WEST SUSSEX COUNTY COUNCIL CONSULTATION

TO:	Arun District Council FAO: Anita Gardner
FROM:	WSCC - Highways Authority
DATE:	24 October 2019
LOCATION:	Broomhurst Lodge Lyminster Road Littlehampton BN17 7QQ
SUBJECT:	LY/11/19/PL New access construction to serve as an access for Broomhurst Farm & its residents.
DATE OF SITE VISIT:	n/a
RECOMMENDATION:	More Information
S106 CONTRIBUTION TOTAL:	n/a

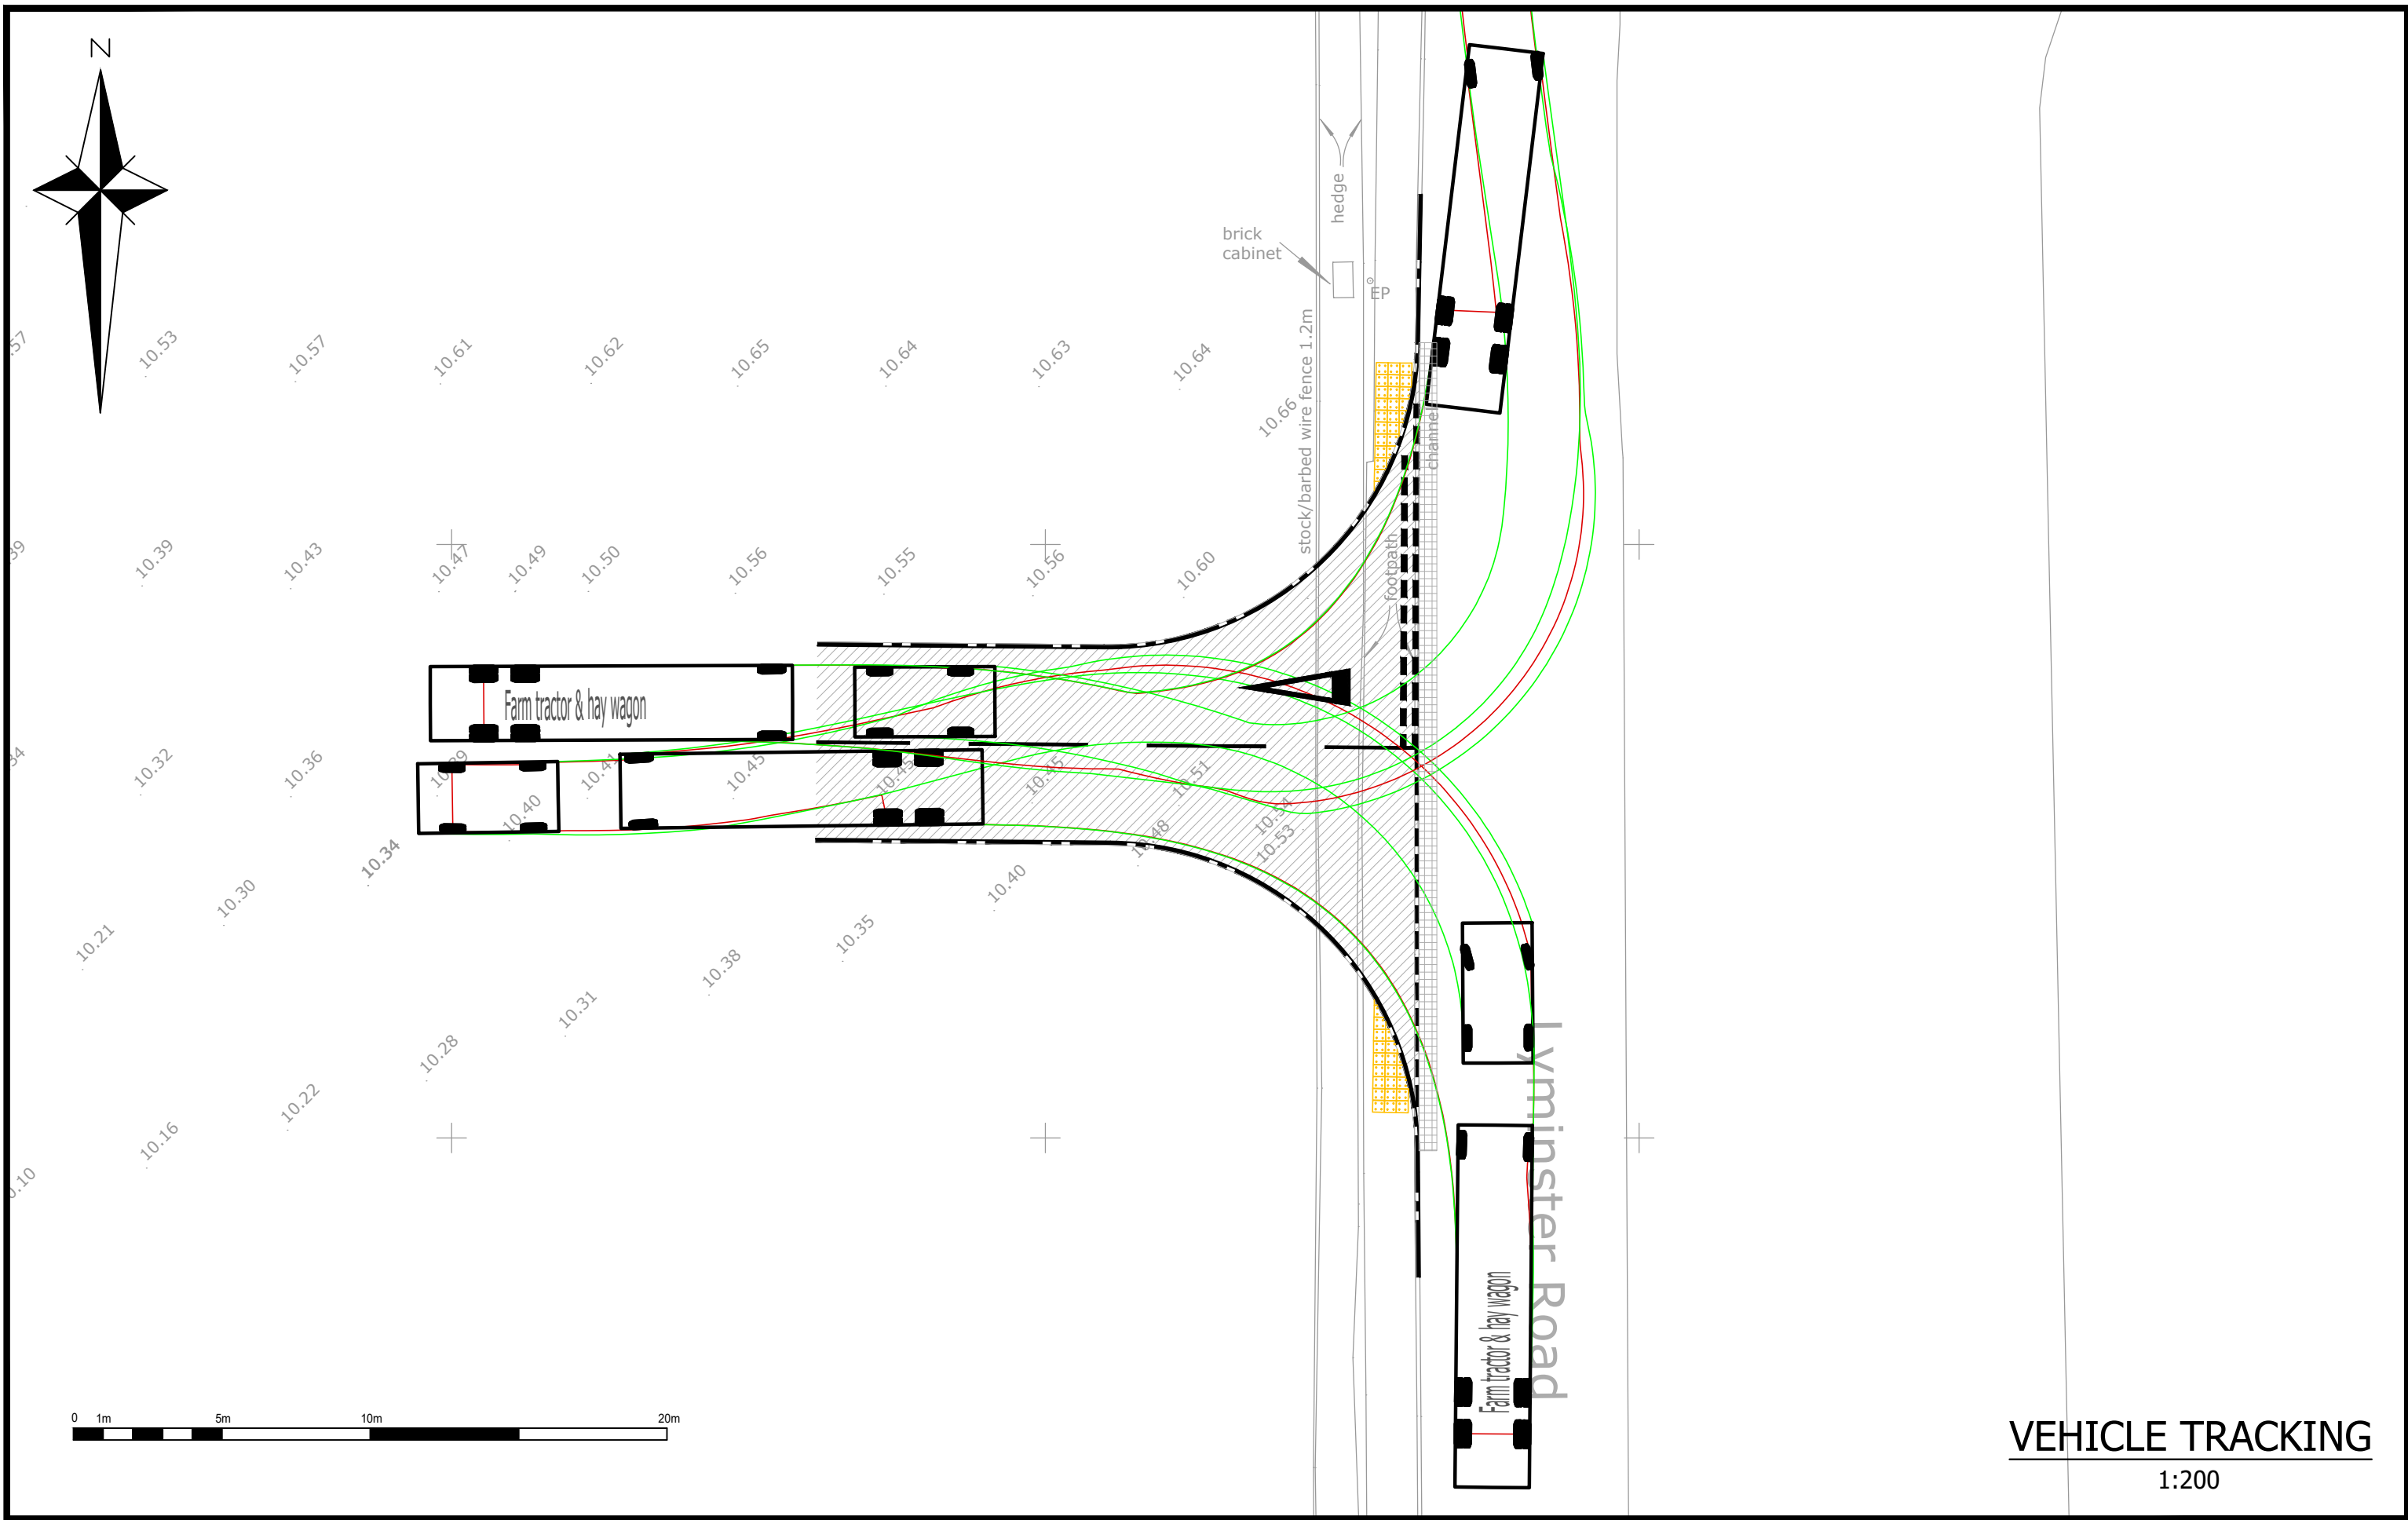
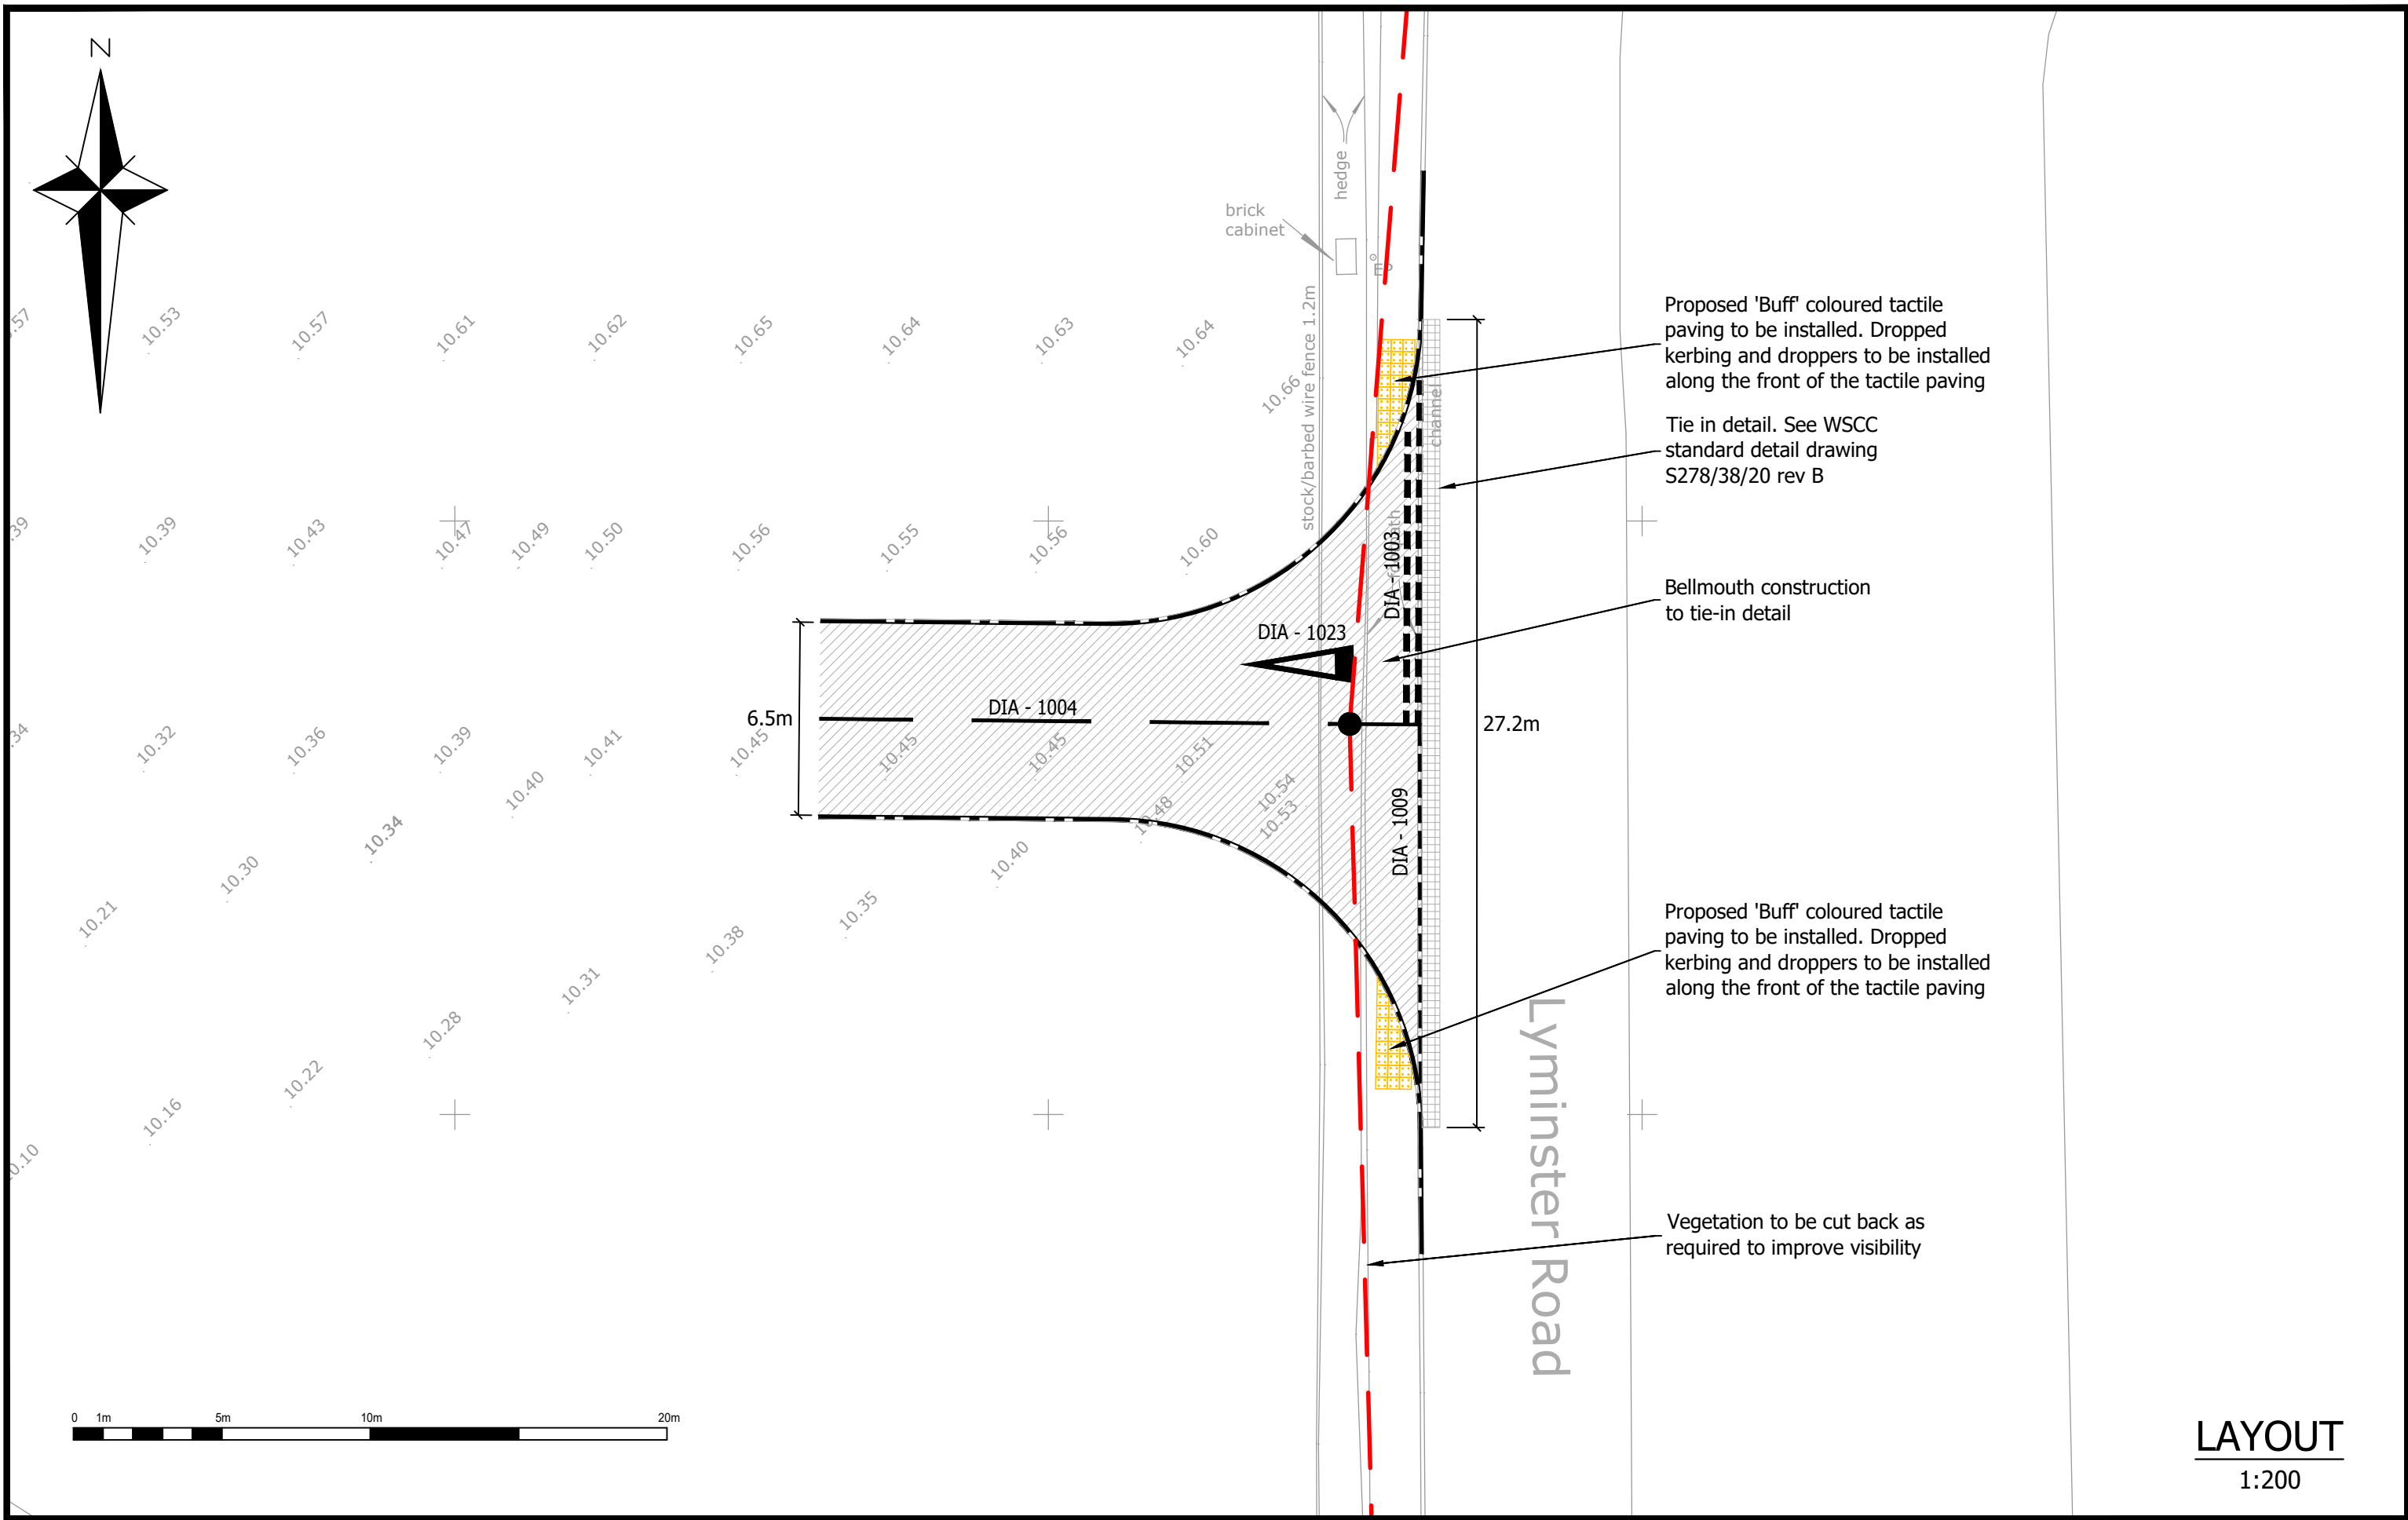
The applicant has provided plans demonstrating the minimum requirement for visibility as per Design Manual for Roads and bridges (DMRB) of 2.4 x 120 metres. The LHA however recognise that visibility in this area is greater than that proposed.

The applicant has demonstrated swept path tracking in accordance with WSCC guidance. This shows that farm traffic would have the ability to enter and exit the proposed access without detrimentally affecting highways safety.
